From: Simon Davis
Sent: 26 February 2020 09:29
To: Planning Scanning
Subject: FW: Planning Consultation on: BE/137/19/RES

Response to Planning Application

Application ref: BE/137/19/RES

Description: Application for approval of phase 2 reserved matters following outline permission BE/63/17/OUT (as amended by BE/131/18/PL) for 20 No. dwellings.

Soft Landscape Layout
The Cottage, Shripney Road, Bognor Regis, West Sussex

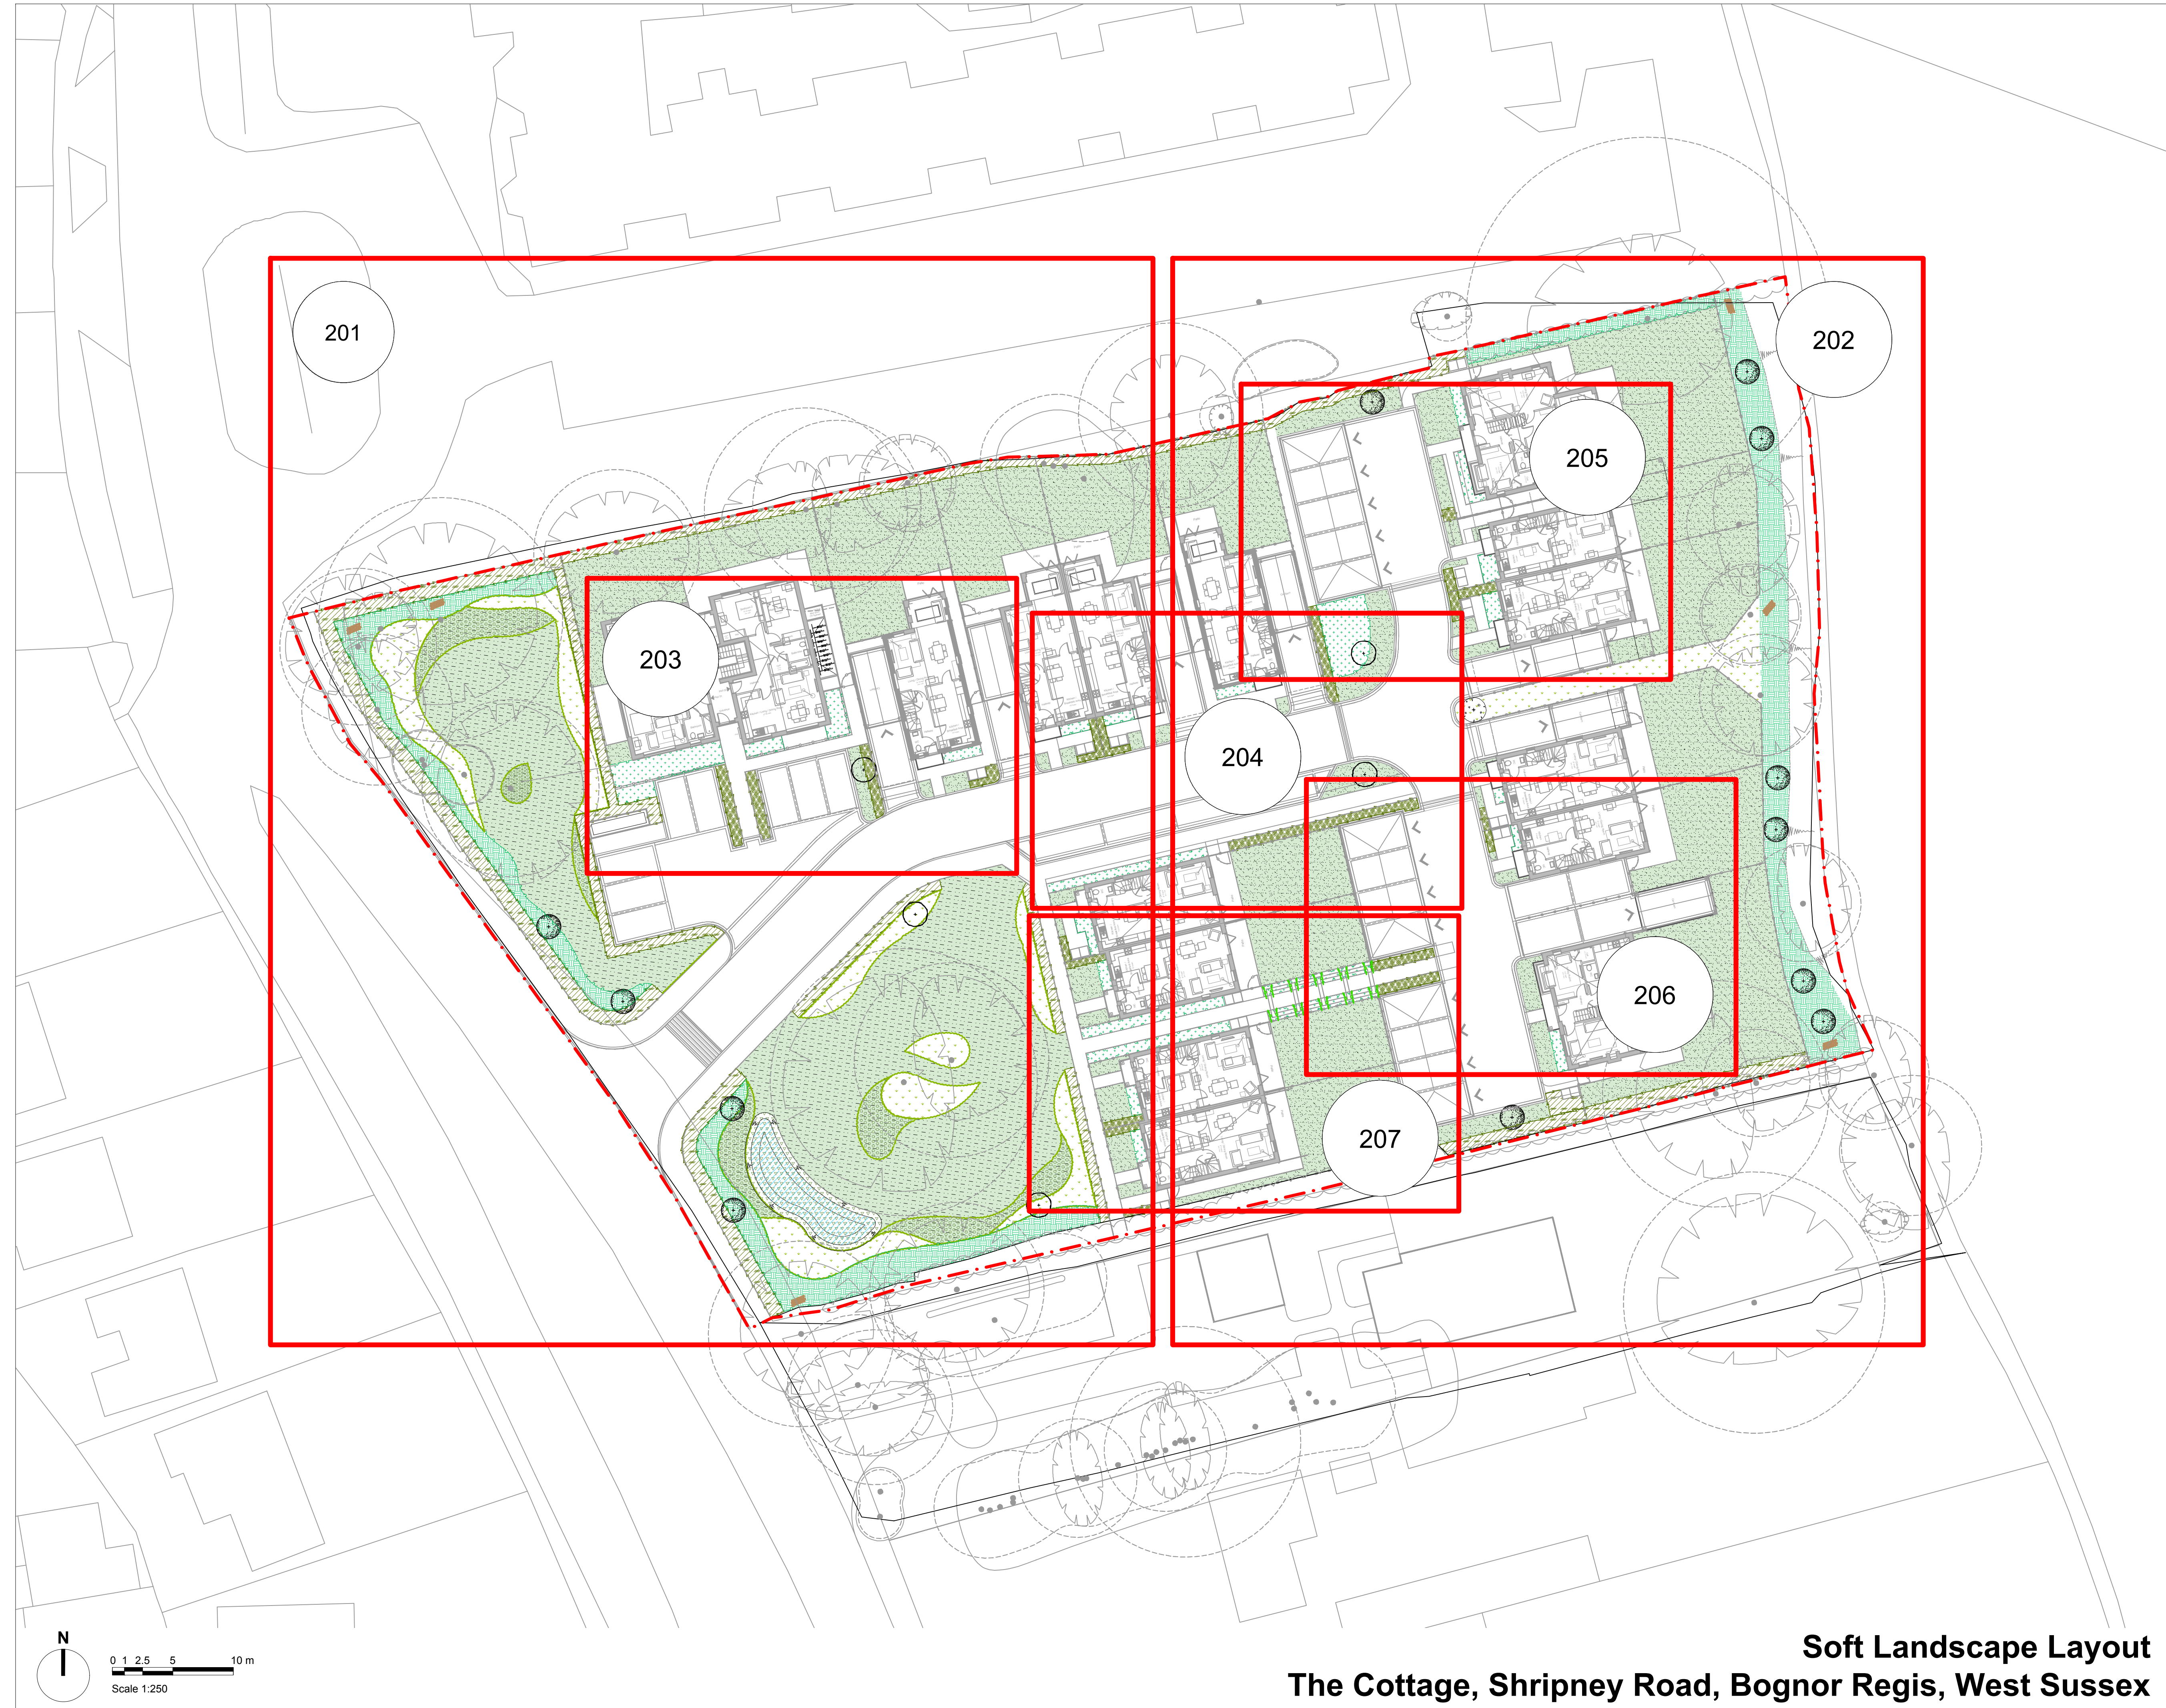
A green buffer to the periphery of the proposals is good to see, with an appropriately sized buffer to the eastern aspect. I would question the commutability of this eastern corridor for wildlife purposes as it is unclear of the connectivity of this area beyond the boundary edge. It is flanked by fences on one side and a bank to the other. As this is a planted area it will over time become inaccessible as an area of POS and may come under future residential pressure to prune as it establishes.

I would request further information re the proposed SuDS which is located within the POS areas. Please request further information regarding water holding periods assumed with this feature also depths of water body and cross sections for this. Drainage provision in relation to the existing trees to be further detailed to ensure no detrimental interference with these. This SuDS area should not be included in the usable POS offer and should be RoSPA (or similar) assessed due to its proximity to dwellings and public realm areas. There is no indication if this is to be a fenced feature – recommend seek detail.
